Application for a non-material amendment following a grant of planning permission. Town and Country Planning Act 1990

TWO STOREY EXTENSION TO DWELLING

H02-0251-14

DR / JS / PRE 03 B

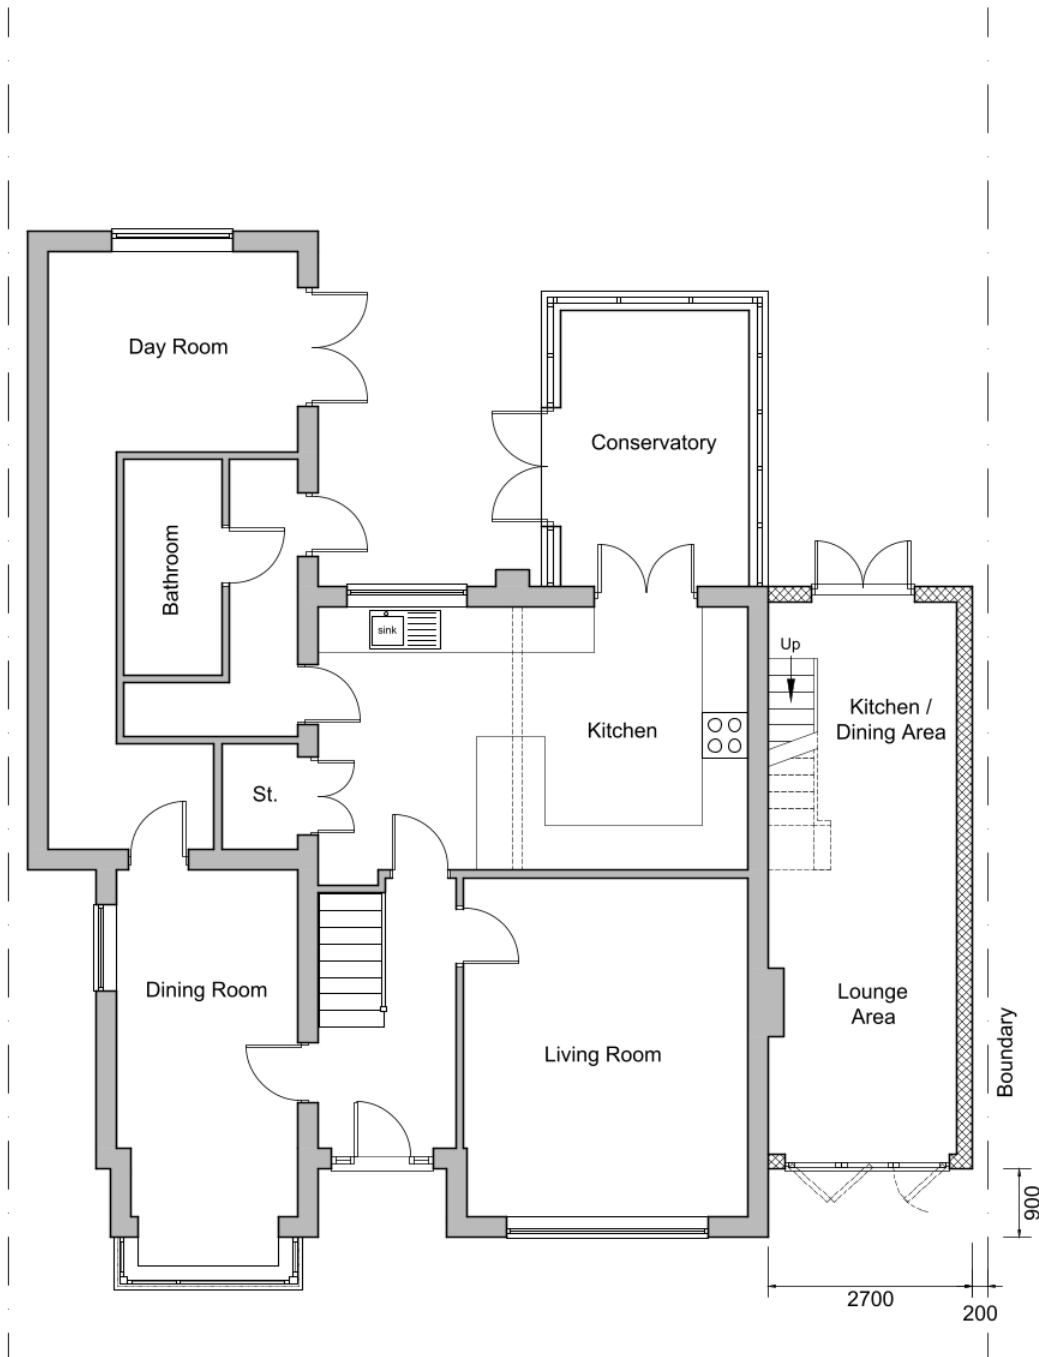
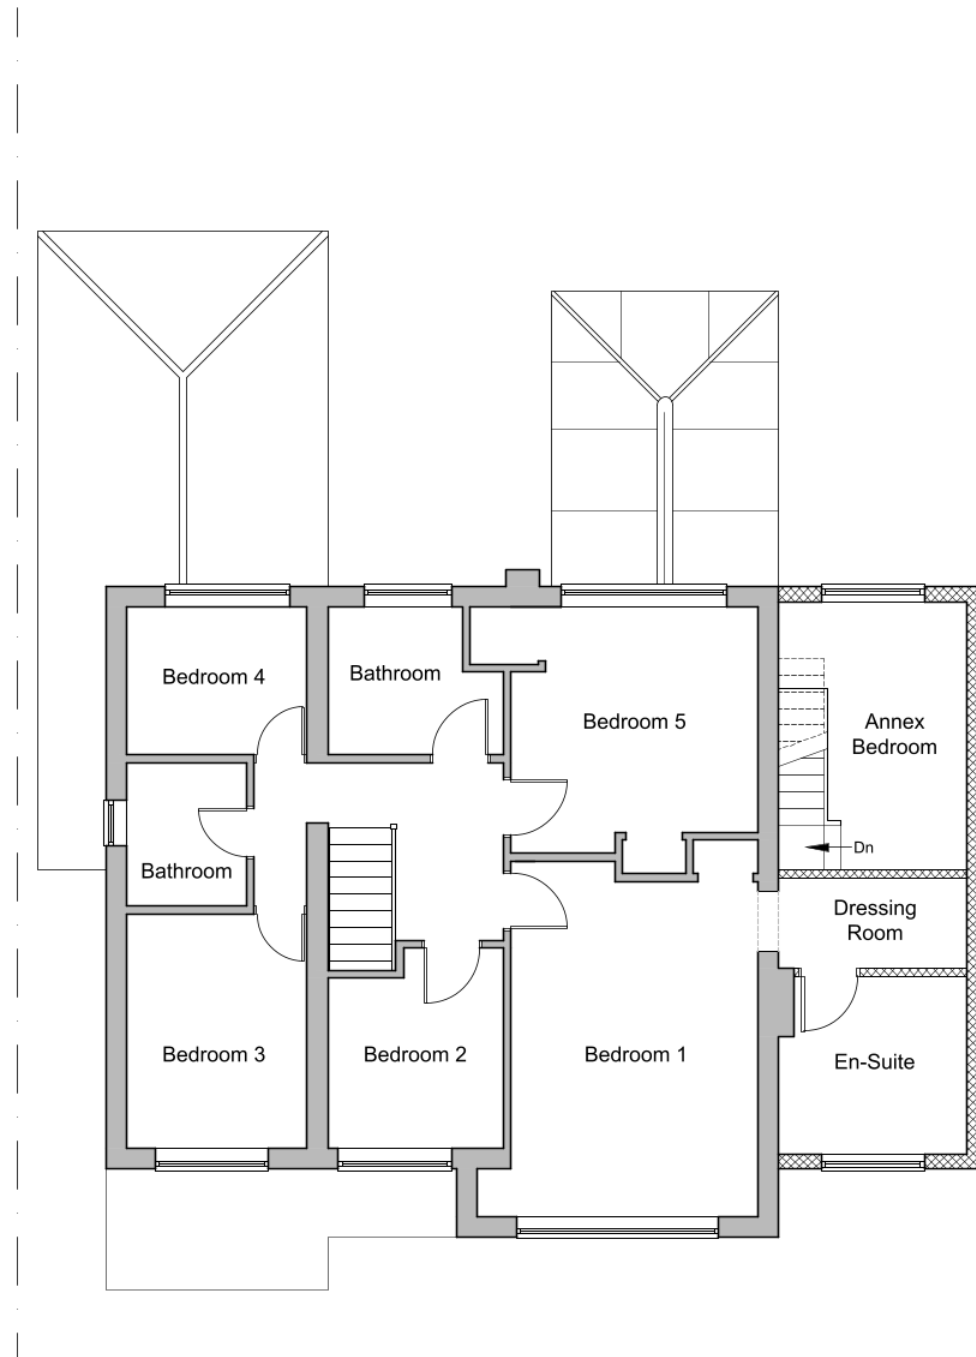
- REMOVE BALCONY SECTION INCLUDING STRUCTURAL STEEL.
- BI FOLD DOORS FRONT & REAR - ALL IN ANTHRACITE GREY INCLUDING WINDOWS & SILL
- CHANGE INTERNAL LAYOUT/USE
- REMOVE SKY LIGHT
